BUNTING MULTIFAMILY FILING NO. 1

A VACATION AND REPLAT OF A PORTION OF LOT 6, LOT 5, AND A PORTION OF LOT 4, STRATMOOR SOUTH SUBDIVISION, SOUTHEAST QUARTER SECTION 5, TOWNSHIP 15 SOUTH, RANGE 66 WEST of

Add PCD file no:
VR-17-009

FINAL PLAT
BUNTING MULTIFAMILY
FILING NO. 1

AS PLATTED
SCALE: 1"= 30'

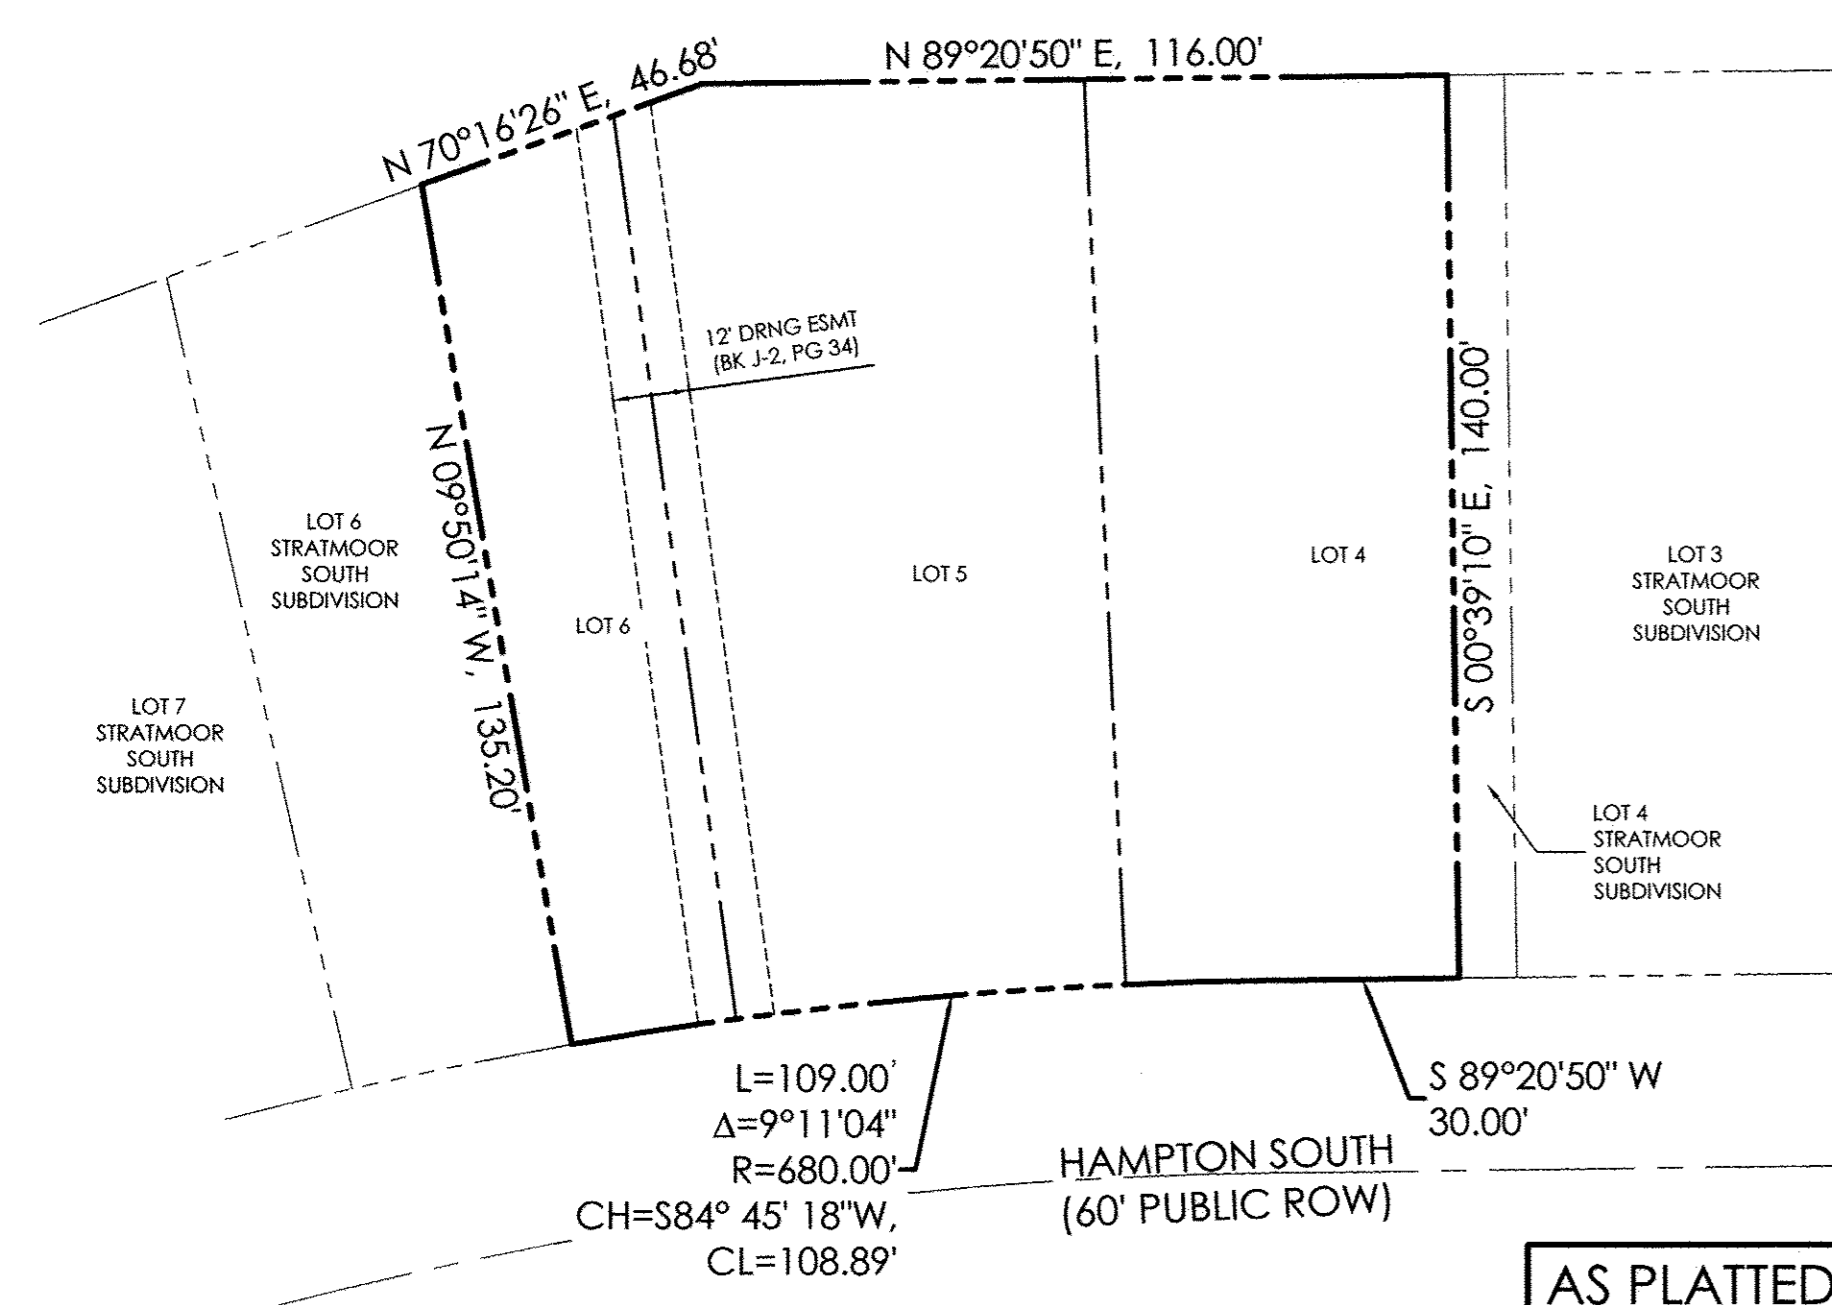
Show the drainage easements identified on the recorded plat (plat no. 2742) or submit the document showing these easements have been vacated.

Show the drainage easements identified on the recorded plat (plat no. 2742) or submit the document showing these easements have been vacated.

AS RE-PLATTED
SCALE: 1"=20'

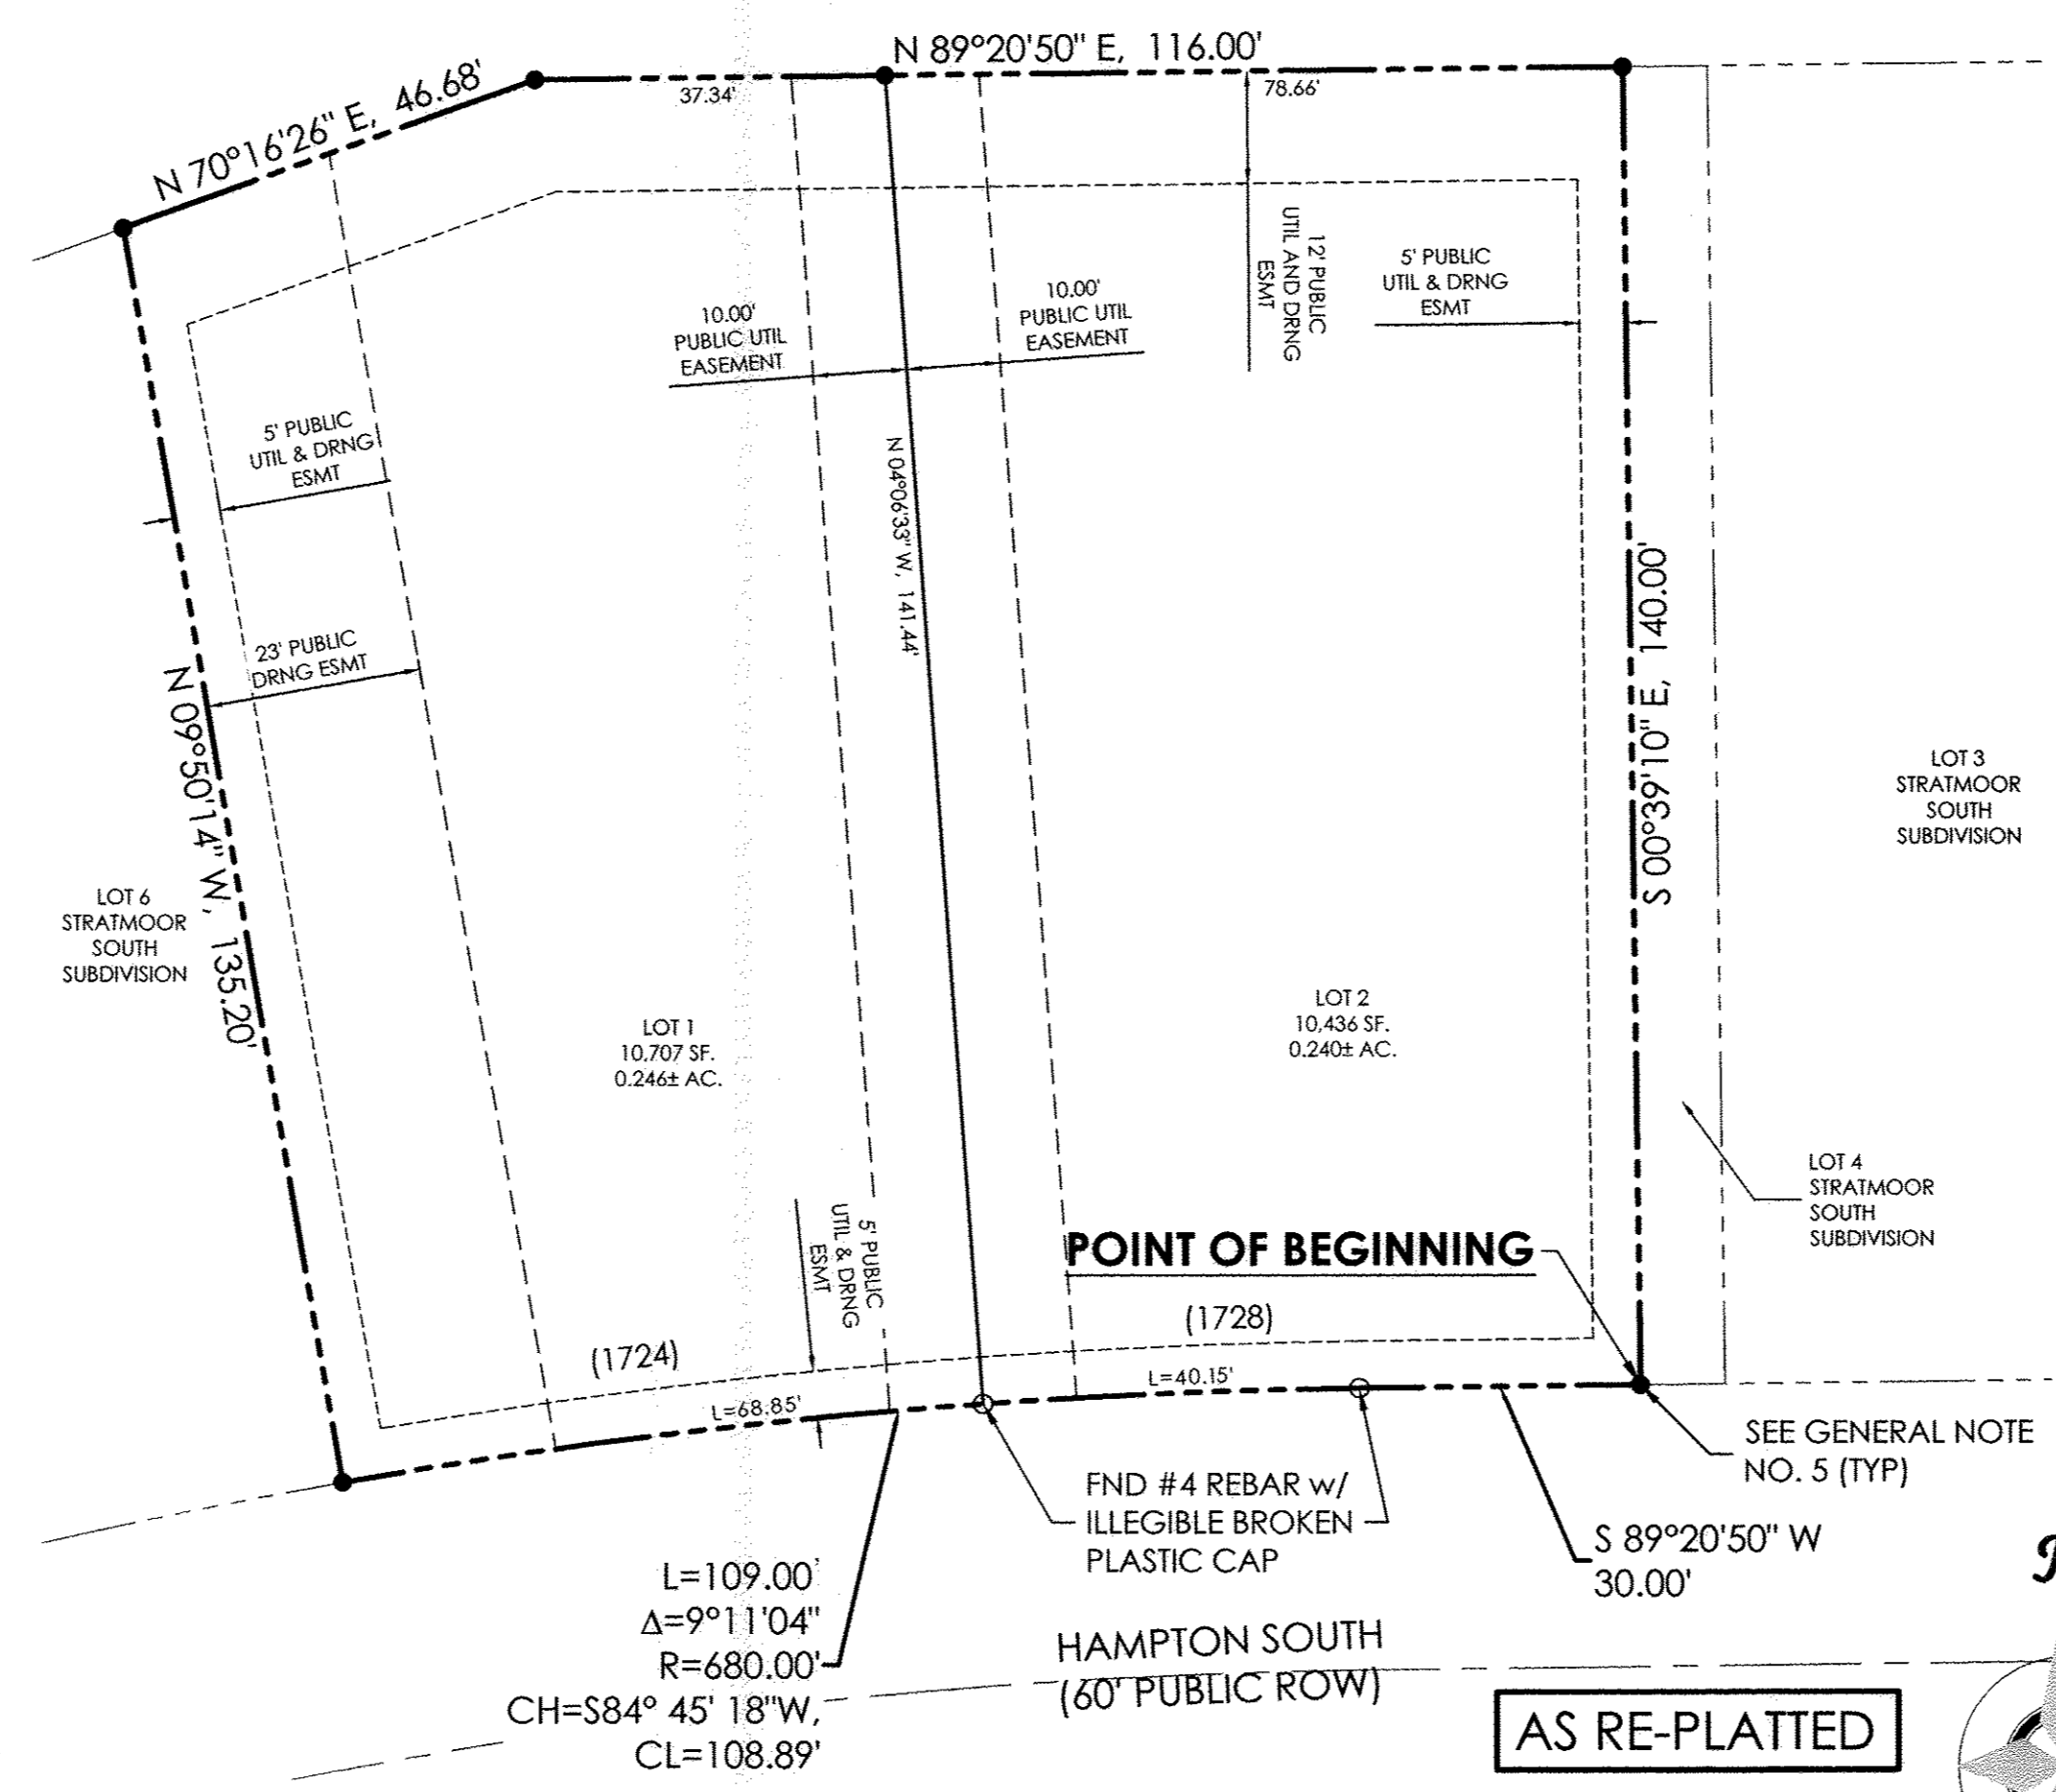
Based on the site layout provide a reciprocal access easement for the lots. A separate agreement should be recorded identifying the terms of the access easement. Add a general note referencing the recorded document.

The LDC requires a 7' rear easement today. The originally plat has 12' easement. If reducing the size we will need written verification that the utility companies are OK with reducing the size and that all lines are within the 7' easement.
